**KIRKLEES METROPOLITAN COUNCIL  
INVESTMENT & REGENERATION SERVICE**

**DELEGATED DECISION TO DETERMINE PLANNING APPLICATIONS**

**Reference No:** 2021/62/91174/E

**Description:** Alterations to convert first and second floor retail to 4 residential units

Proposed Second Floor

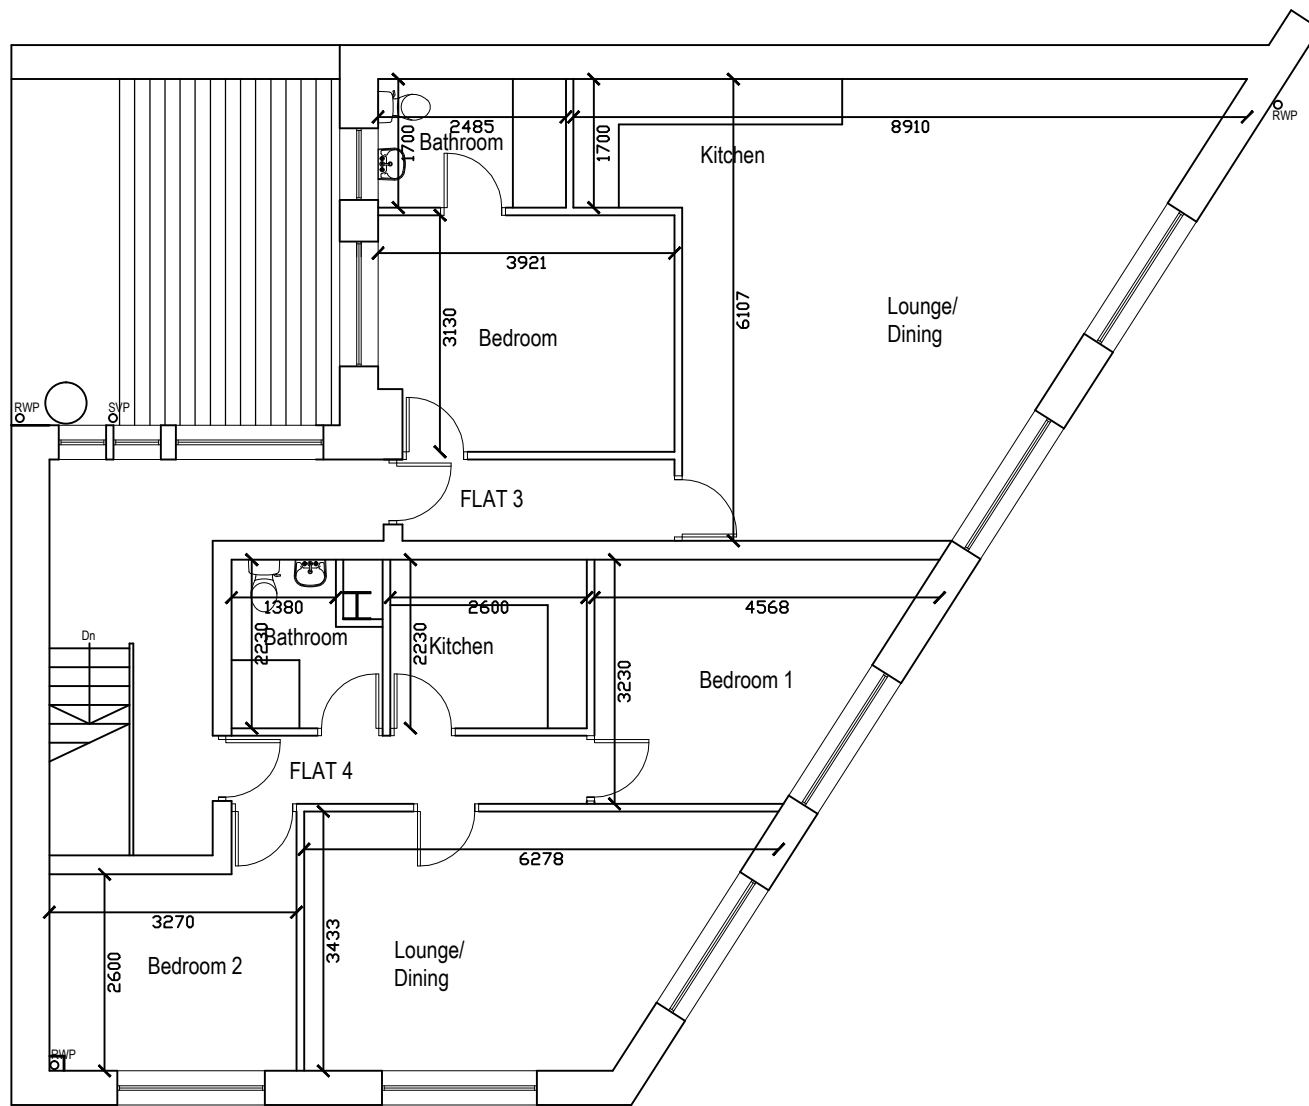
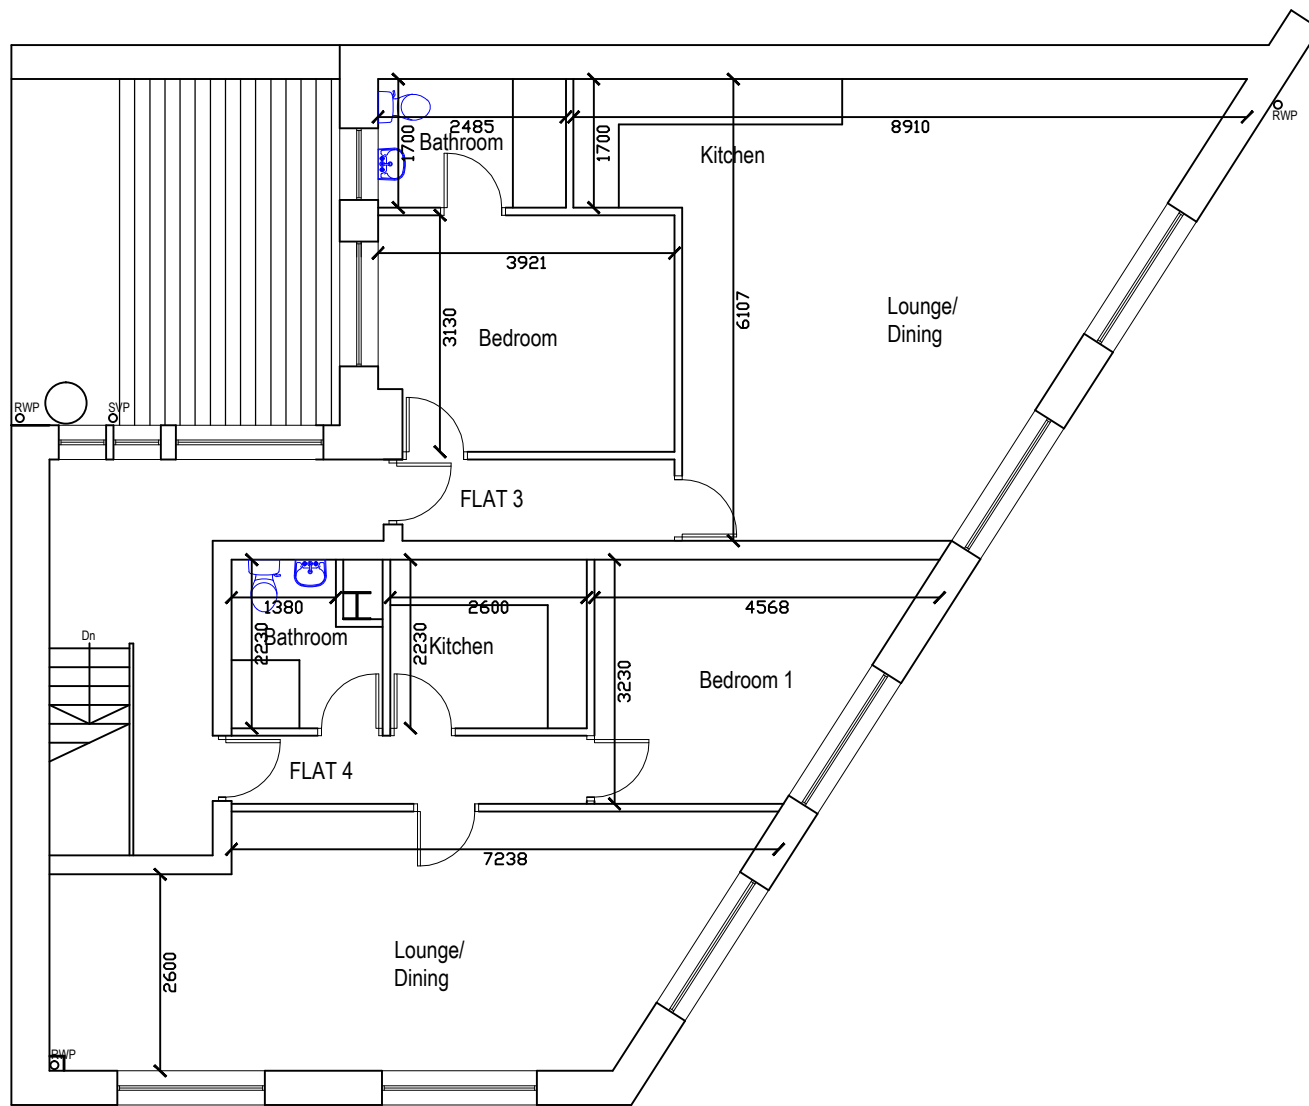
The application initially sought permission for a two-bedroom flat on the second floor amongst the three one-bed flats still proposed. This was considered insufficient in size to ensure a good standard of amenity for future occupiers. It was also below the required sizes set out in the technical housing standards. The agent amended the plans to propose 4no one bed flats, which are being considered in this report.
